KITTITAS COUNTY

MEMORANDUM

TO: All Staff
FROM: Public Works Plan Review Team
DATE: April 1, 2025
SUBJECT: SP-25-00005 Hanson

HANSON ROAD SHORT PLAT
 PART OF SECTION 11, T. 17 N., R. 17 E., W.M.
 KITTITAS COUNTY, WASHINGTON

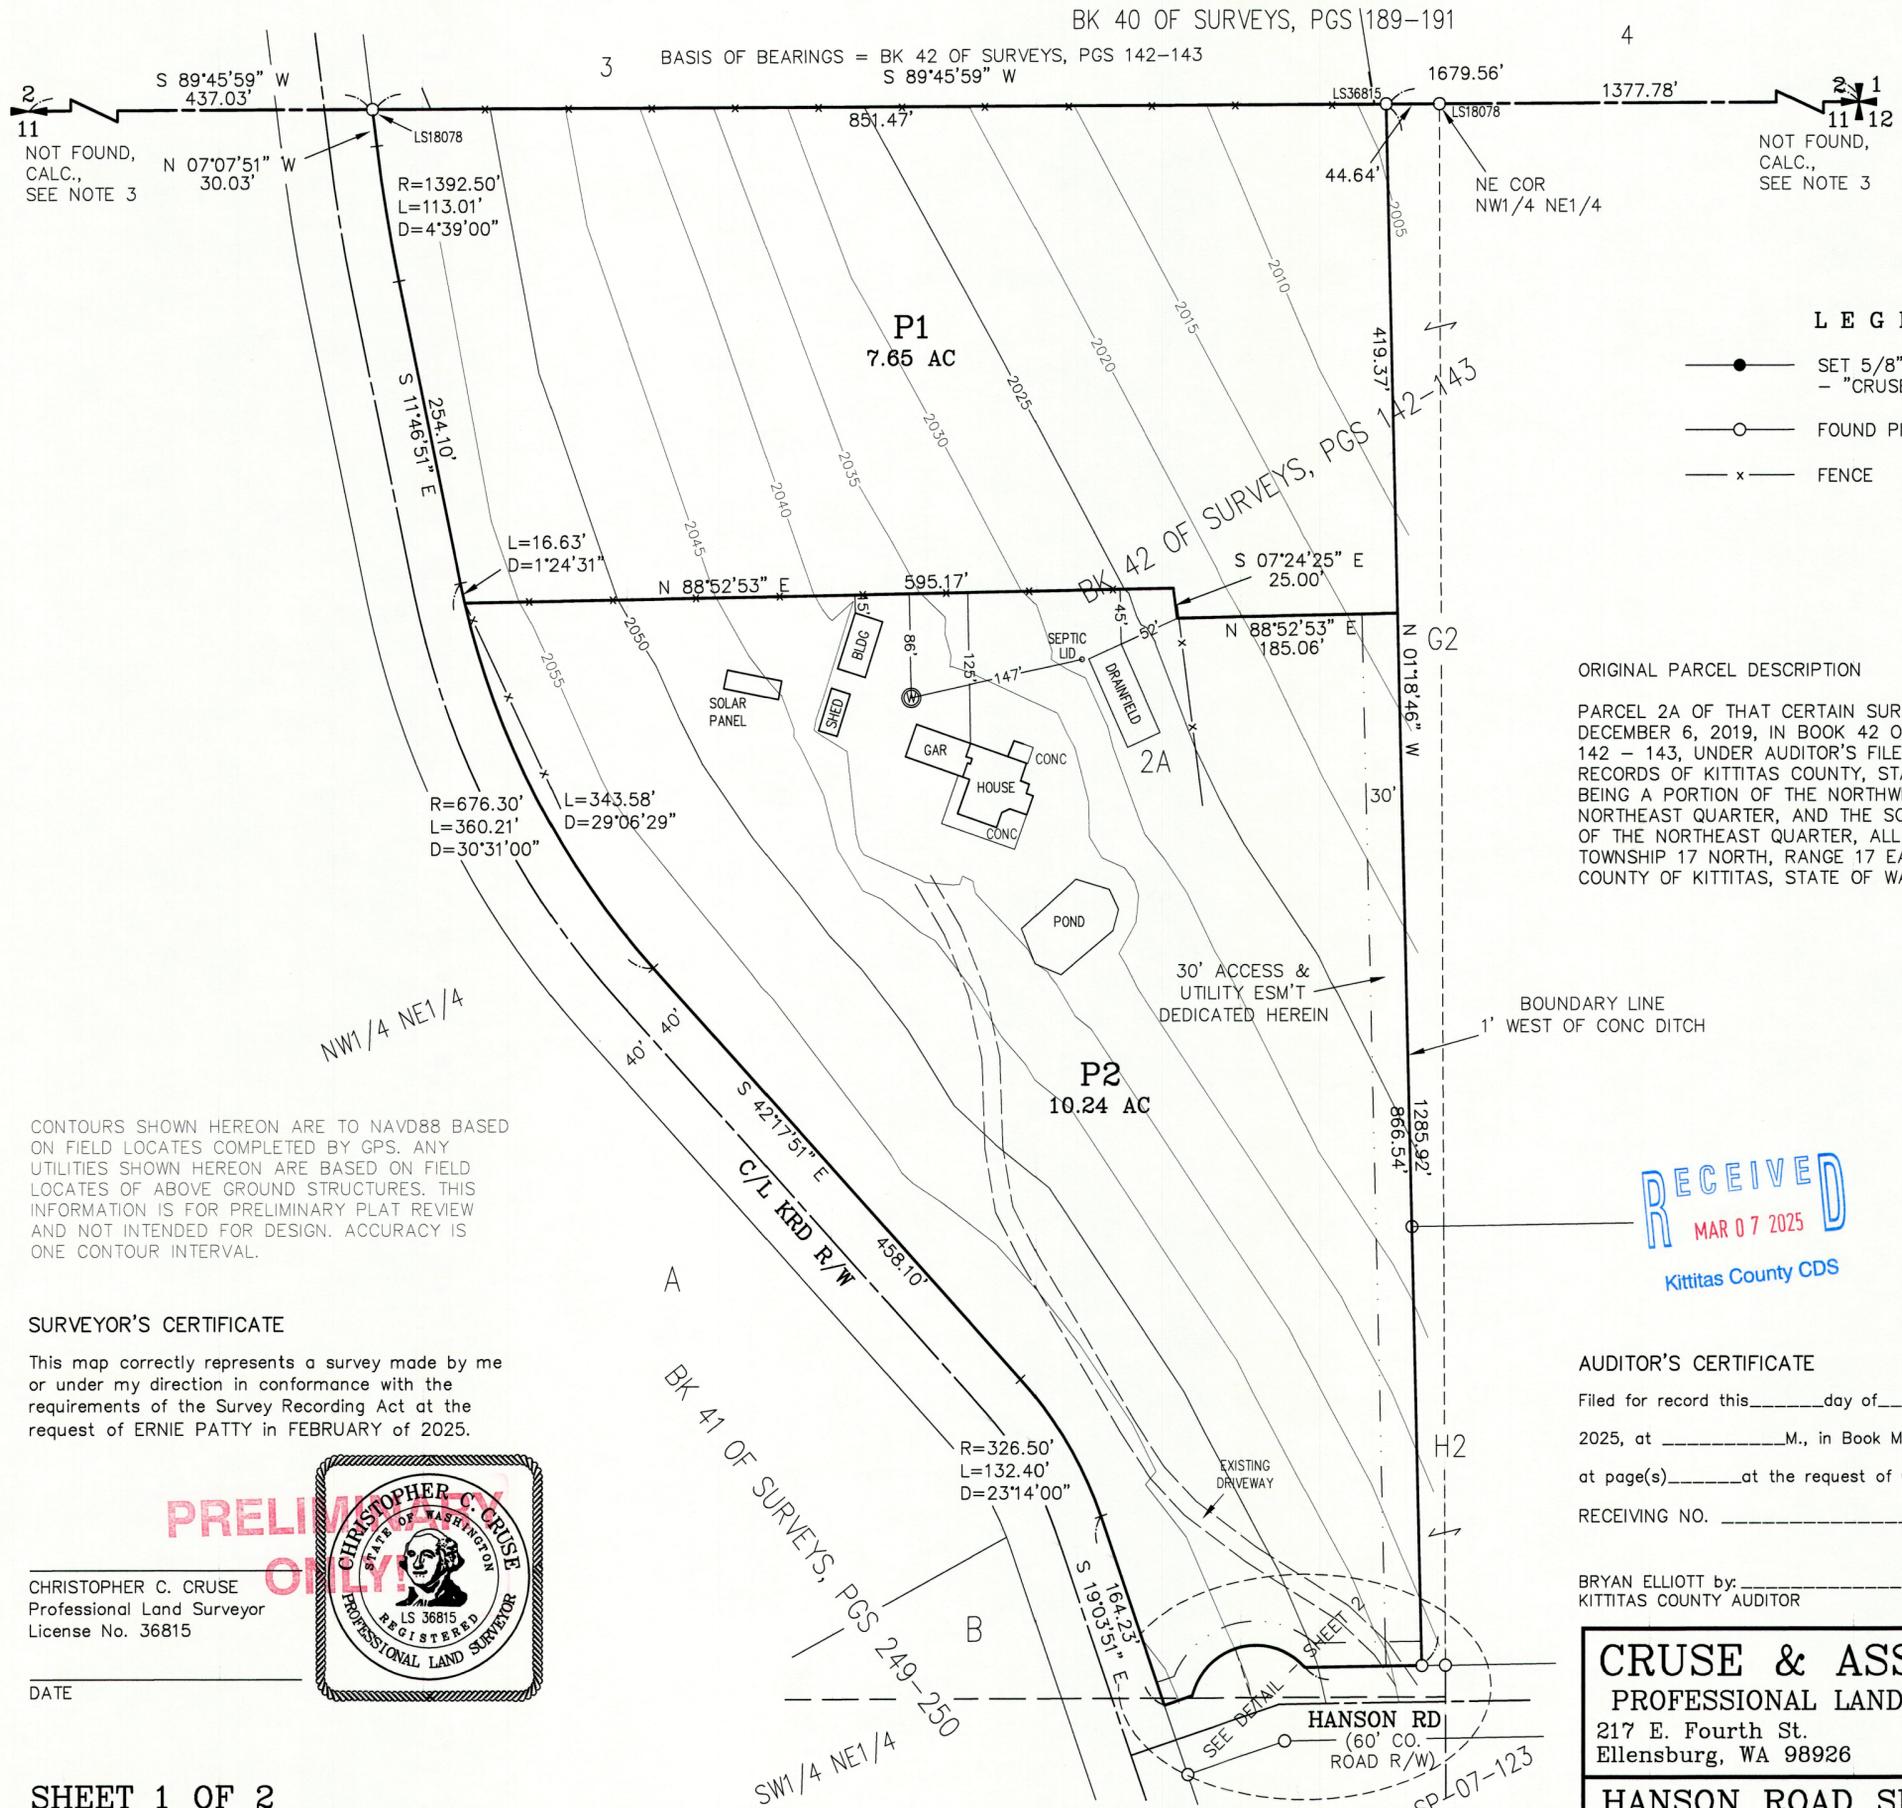
SURVEY	<ol style="list-style-type: none"> 1. The proposed new boundary does not meet the setback requirements of KCC:17.29.080. 2. Of the 8 property corners shown, only 3 can be mathematically retraced from this survey. If any of the others have been utilized for survey control, ties to them shall be shown on the face of the survey. 3. The detail window on sheet 2 appears to have the West line of the access easement drawn in the incorrect position. (JT)
TRANSPORTATION CONCURRENCY	No transportation concurrency requirement for this project. (KAH)
FLOOD	Parcel #960081 is not within a FEMA identified special flood hazard area (100-year floodplain). A floodplain development permit is not required. (SC)
